## **Boston Alternative Energy Facility**

### Comments on Examining Authority's First Written Questions

Client: Alternative Use Boston Projects Ltd.

Planning Inspectorate EN010095

**View 3:** Photomontage view of the proposed facility at Year 1

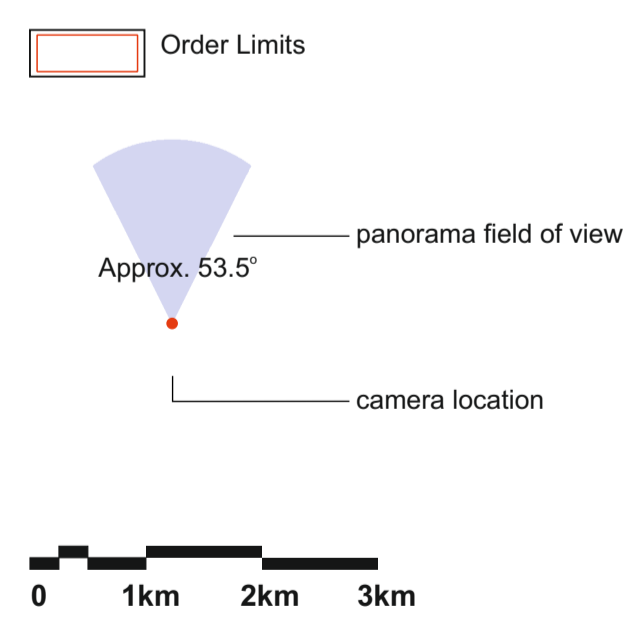
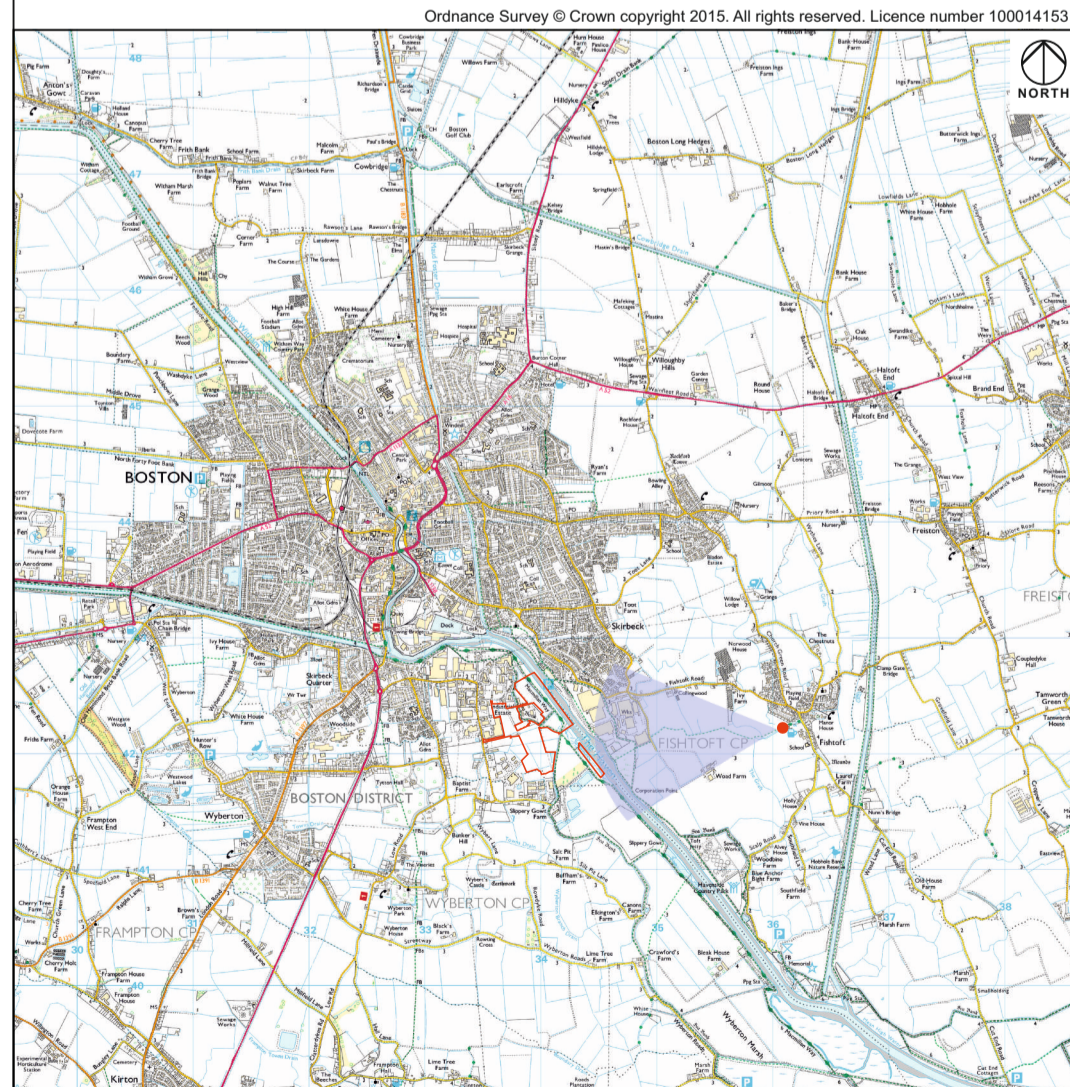
Q3.0.10	The Applicant	<p>Please can the Applicant provide a photomontage that depicts the visible plumes that would be produced by the five stacks that form part of the Proposed Development.</p>	<p>The Applicant has updated the photomontages submitted within the application to depict visible plumes. These figures have been submitted at Deadline 2 as follows:</p> <ul style="list-style-type: none"> <li>• Chapter 9 Figure 9.15 (document reference 6.3.7(1)); and;</li> <li>• Chapter 9 Figure 9.17 (document reference 6.3.9(1)).</li> </ul>

ExQ1	Question is addressed to	Question	Applicant Response
			<p>The two views selected illustrate plume effects in a distant view (View 3) and in a close range view (View 8). In both cases the angle of the view is broadly perpendicular to the plume direction of travel and as such illustrates a ‘worst case’, full extent of plume dispersal.</p>
Q3.0.11	The Applicant	<p>ES paragraph 5.6.73 anticipates that the thermal process would produce residual material of approximately 200,000 tonnes of ash and just under 17,000 tonnes of Air Pollution Control Residues (APCr), which would then be processed in the LWA facility onsite to produce aggregate that would be exported offsite by ship. However, paragraph 5.6.19 refers to just over 200,000 tonnes of ash and just under 100,000 tonnes of APCr, which is consistent with Work No. 2 in the dDCO that refers to up to 300,000 tonnes of aggregate in total. Please can the Applicant confirm which are the correct figures and which have informed the assessments in the ES.</p>	<p>Paragraph 5.6.19 of Chapter 5 Project Description (document reference 6.2.5, APP-043) is referring to the amount of aggregate produced (consistent with Work No. 2). It notes that “just over 200,000 tonnes (design point = 201,890 tonnes) of LWA would be produced from bottom ash residues, and just less than 100,000 tonnes (design point = 97,531 tonnes) from APC residues.”</p> <p>Paragraph 5.6.73 is referring to the amount of ash and APCr which will be removed from the combustion plant to be transferred to the lightweight aggregate plant for processing. This paragraph notes “It is anticipated that approximately 200,000 tonnes (198,242 tonnes) of ash and just less than 17,000 tonnes (16,667 tonnes) of APCr will become residual material to be removed from the combustion plant.”. Further information on the process is provided below.</p> <p>The three energy from waste lines are effectively part of a main process which will normally operate continuously and from up to 1.2 million tonnes of fuel input produce circa 200,000 Tonnes of bottom ash plus 17,000 Tonnes of APCr ash – continuously but averaged out</p>

BOSTON ALTERNATIVE ENERGY FACILITY DEVELOPMENT CONSENT ORDER
 Regulation 5(2)(k) - Access and Rights of Way Plan
 BOSTON BOROUGH COUNCIL
 Sheet 1 of 1

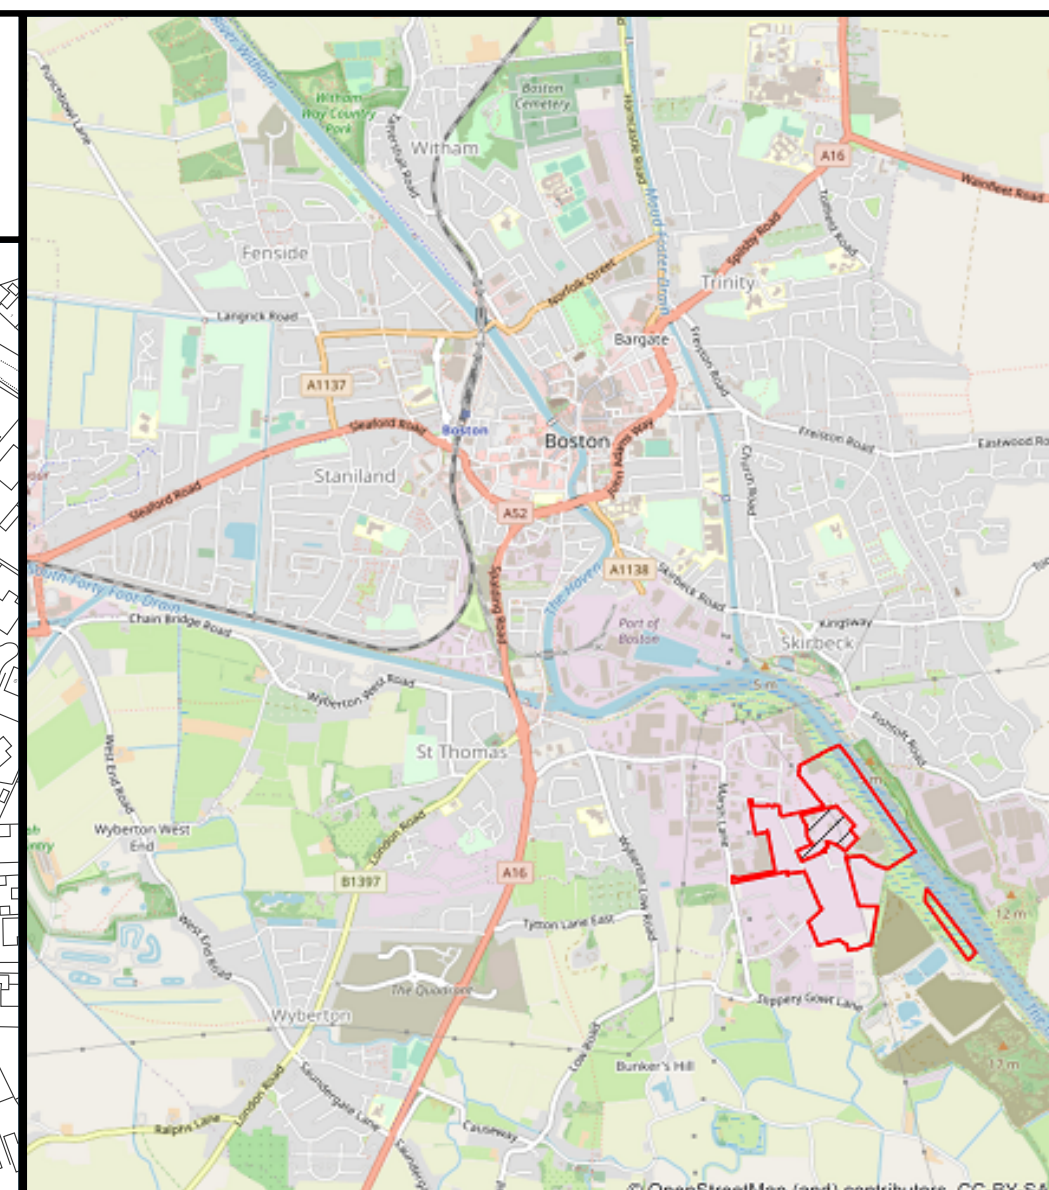
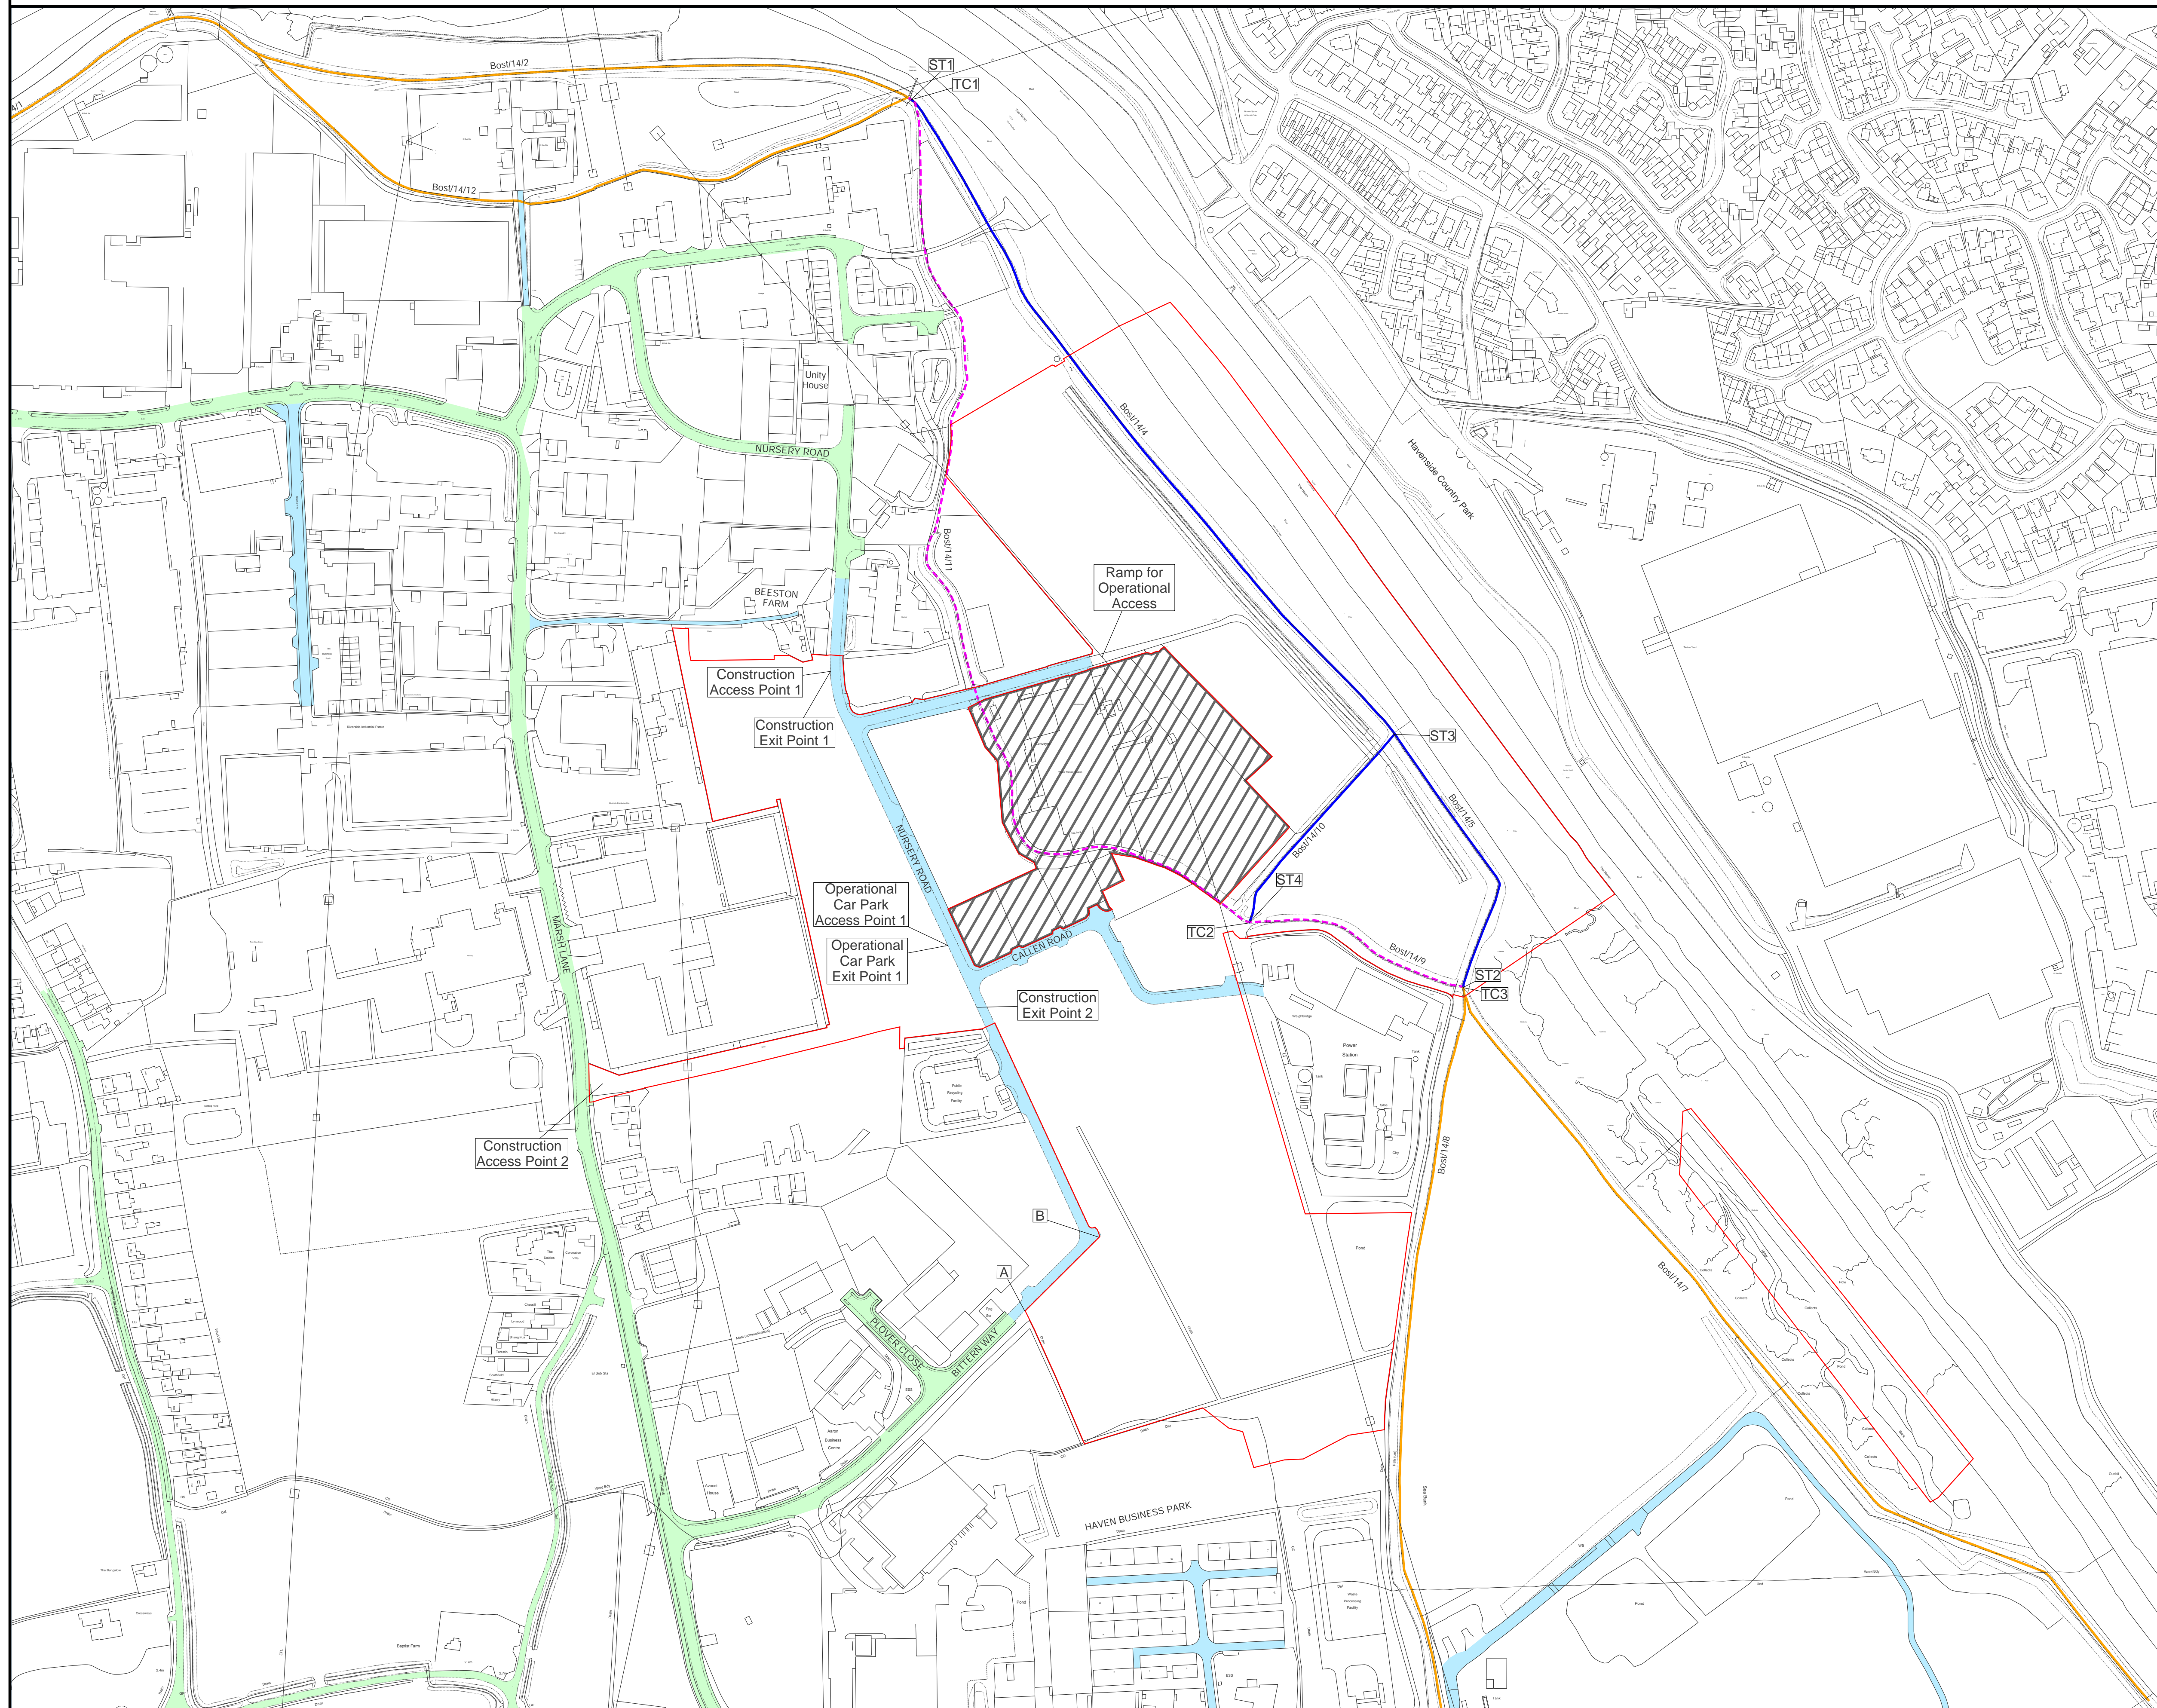
ExQ1	Question is addressed to	Question	Applicant Response
<b>1. General and Cross-topic questions</b>			
Q1.0.1	The Applicant	The works plans are hard to read; please show size of buildings and limits of deviation on the plans.	<p>Additional drawings have been submitted to show the required information as follows:</p> <ul style="list-style-type: none"> <li>• The Works Plans (document reference 4.3(1)) have been updated to provide more clarity and to include 20m limits of deviation (see sheets 9-15).</li> <li>• The Indicative Generating Station Plans (document reference 4.9, APP-019) show the locations of buildings and the size of buildings has been added onto sheet 10 of 10 of the Indicative Generating Station Plans (document reference 4.9(1)).</li> </ul>
Q1.0.2	The Applicant	Please provide lower resolution plans suitable for use in the virtual environment.	<p>Lower resolution plans have been submitted as follows:</p> <ul style="list-style-type: none"> <li>• Location Plan (document reference 4.1);</li> <li>• Land Plan and Crown Land Plan (document reference 4.2);</li> <li>• Works Plans (document reference 4.3(1));</li> <li>• Illustrative Landscape Plan (document reference 4.4);</li> <li>• Statutory and Non-Statutory Sites or Features of Nature Conservation and Habitats Plan (document reference 4.6);</li> <li>• Water Bodies in a River Basin Management Plan (document reference 4.7);</li> <li>• Heritage Assets (document reference 4.8);</li> <li>• Indicative Generating Station Plan (document</li> </ul>

ExQ1	Question is addressed to	Question	Applicant Response
			<p>reference 4.9(1));</p> <ul style="list-style-type: none"> <li>• Indicative Electrical and Water Connection Plan (document reference 4.10); and</li> <li>• Indicative Wharf Plans (document reference 4.11).</li> </ul> <p>The Access and Rights of Way Plan (document reference 4.5) has not been re-submitted as it was already compressed to the maximum amount.</p>
Q1.0.3	The Applicant and Lincolnshire CC (LCC)	<p>LCC have queried the s42 consultation on the revised technology for the plant.</p> <p>Please detail the differences between the processes; gasification (the original proposal) and thermal treatment; and any mitigation proposed.</p>	<p>Gasification is a process in which a fuel (waste in the case of the Facility) is heated to a high temperature (&gt;700°C) under carefully controlled starved air conditions. This produces an inert carbon “char” and a “syngas” (a mixture of carbon monoxide and hydrogen), which is then combusted to generate heat and electricity via a steam turbine. This was the original technology proposed for the Facility (as set out in the Preliminary Environmental Information Report (PEIR)). It incorporated air pollution abatement equipment downstream of the syngas combustion chamber in order to achieve compliance with the emission limit values (ELV) specified in the EU Best Available Techniques Reference (BREF) Documents.</p> <p>The thermal treatment process now proposed for the Facility is an established step grate conventional combustion process, where the fuel (waste) is burned with an excess of air to achieve as complete combustion as possible in the furnace. The combustion gases then pass into a secondary combustion chamber, where they are heated to at least 850°C for at least 2</p>
